Subject: Y/26/21/DOC

Given the time the application has been open and the number of outstanding points we would support a refusal of Condition 11, and would recommend that the following reasons are included within that refusal:

Redrow Construction Phase Plan

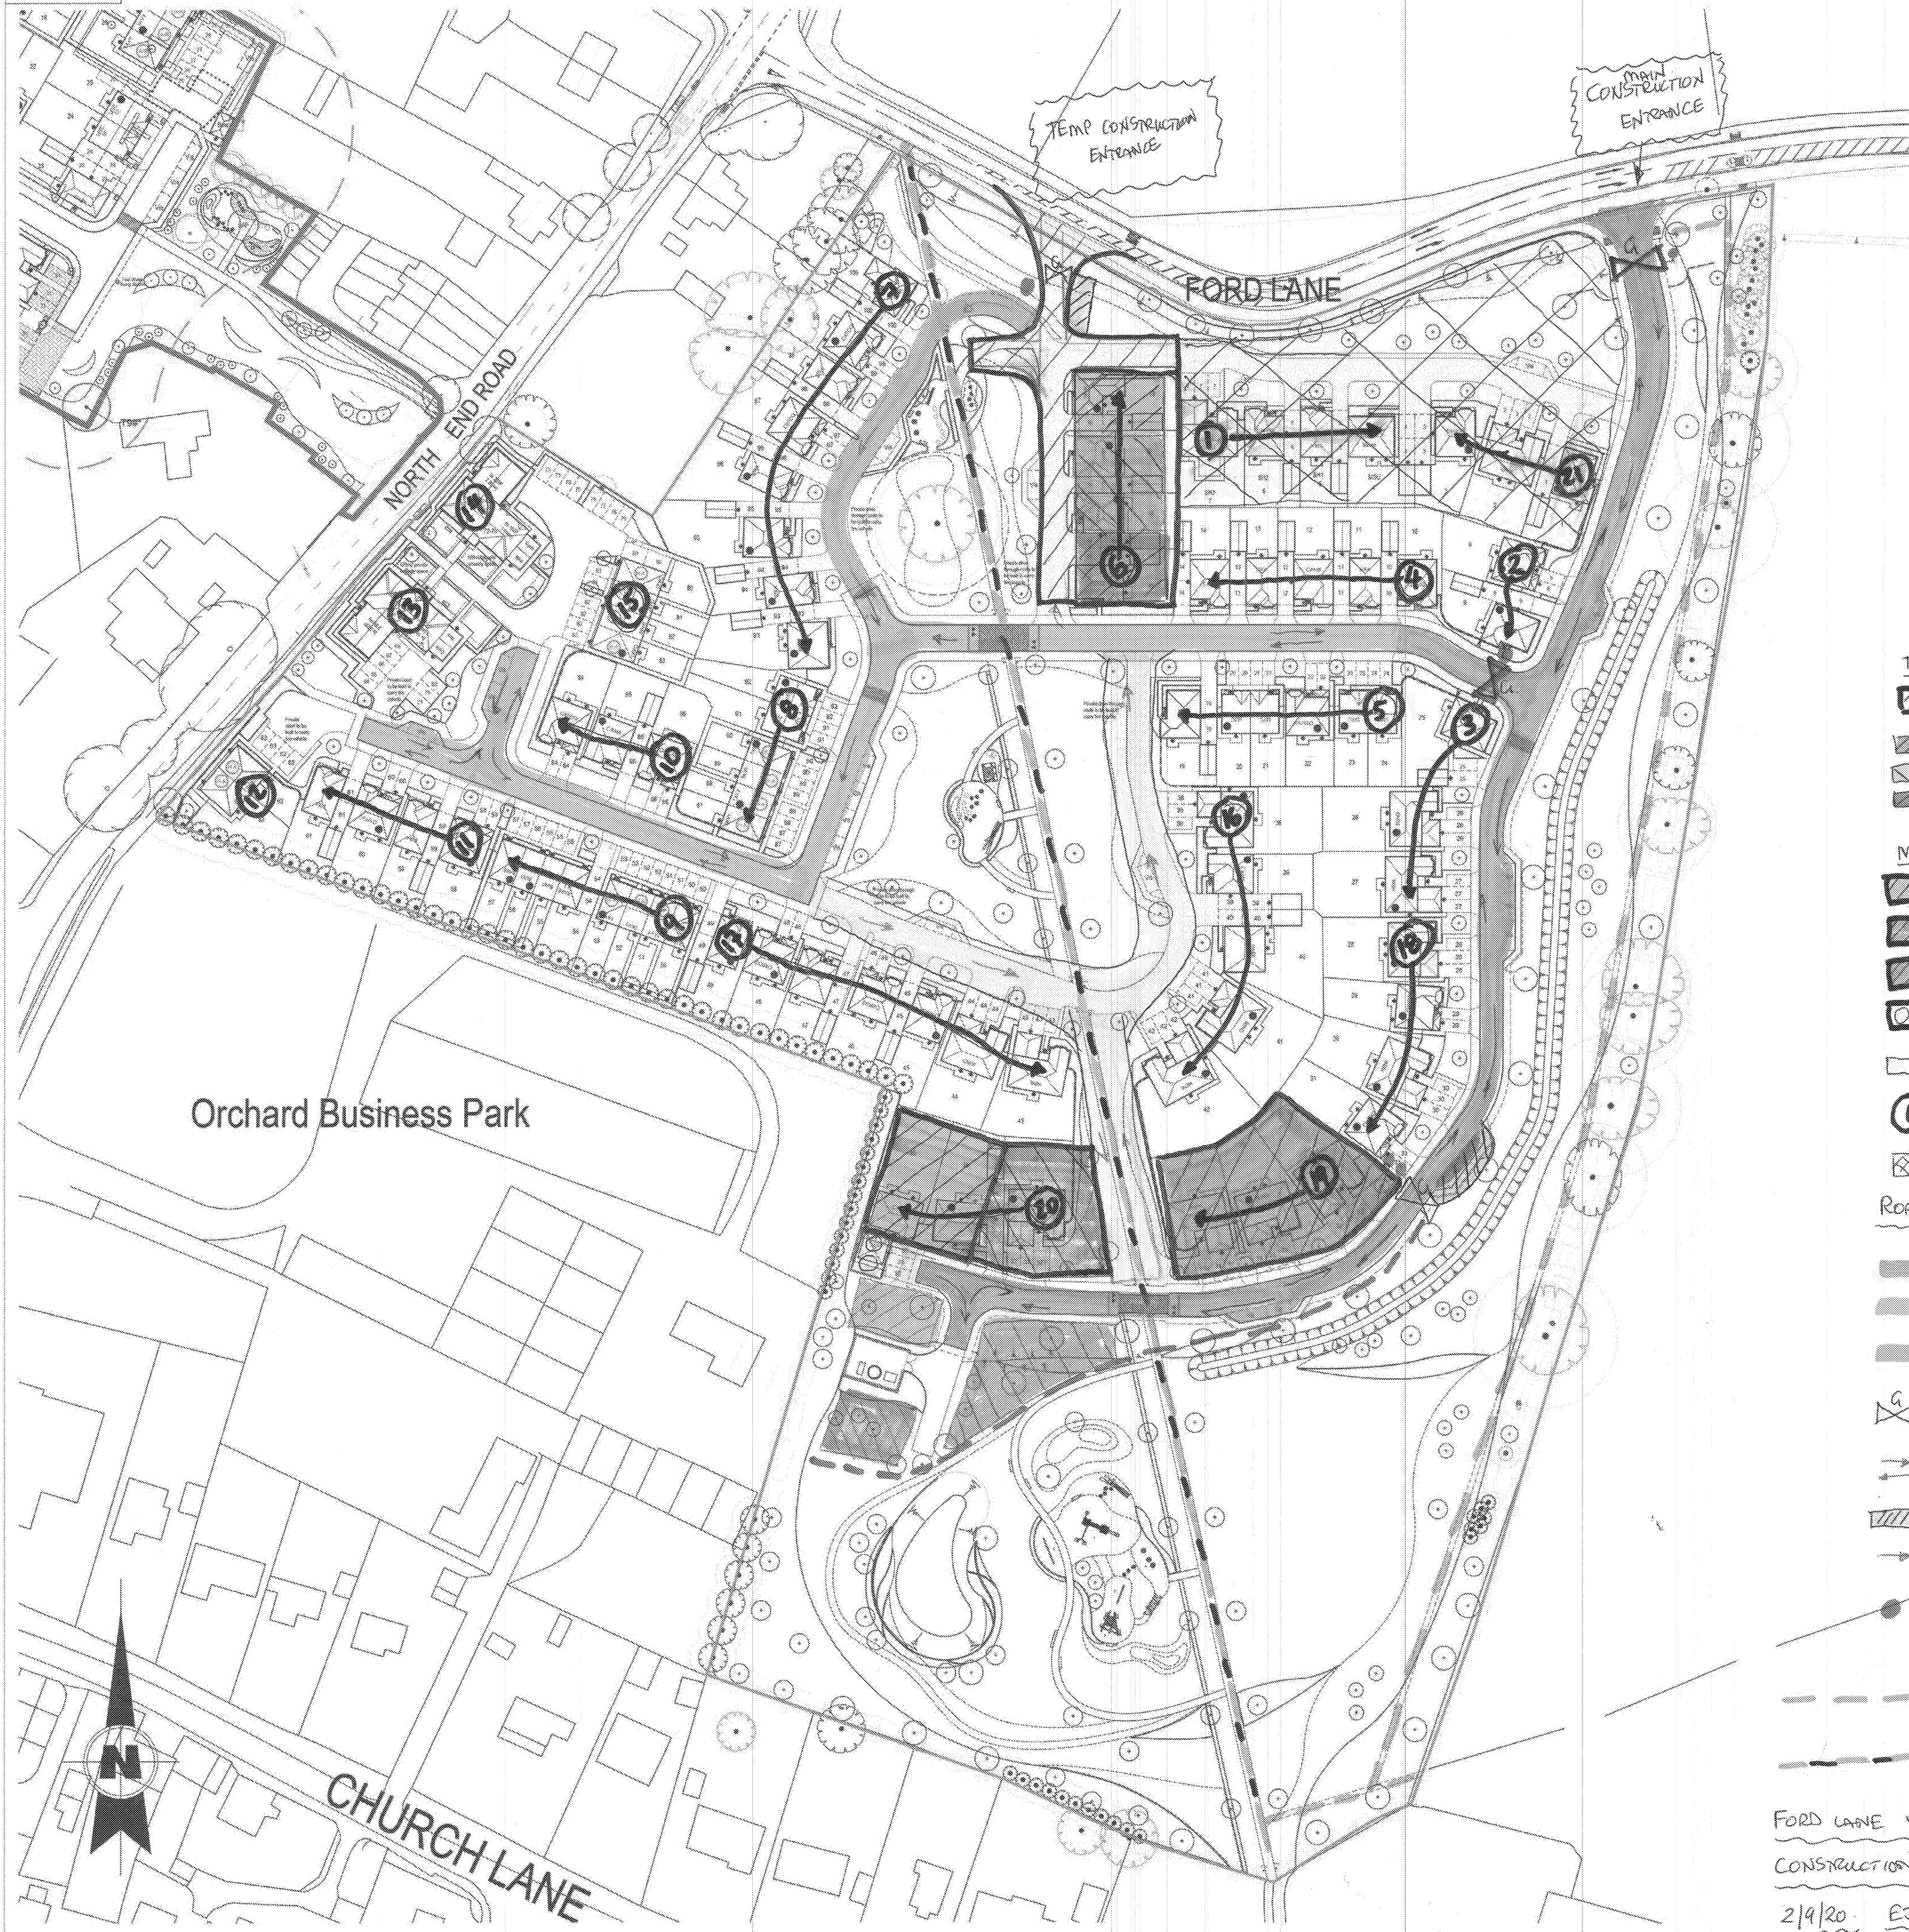
5. Details on the timescales for implementation are very poor. The order of construction including drainage has not been clearly defined. It must be very clear how it will be ensured that the drainage elements serving each phase of development will be constructed and completed prior to occupation of these phases.
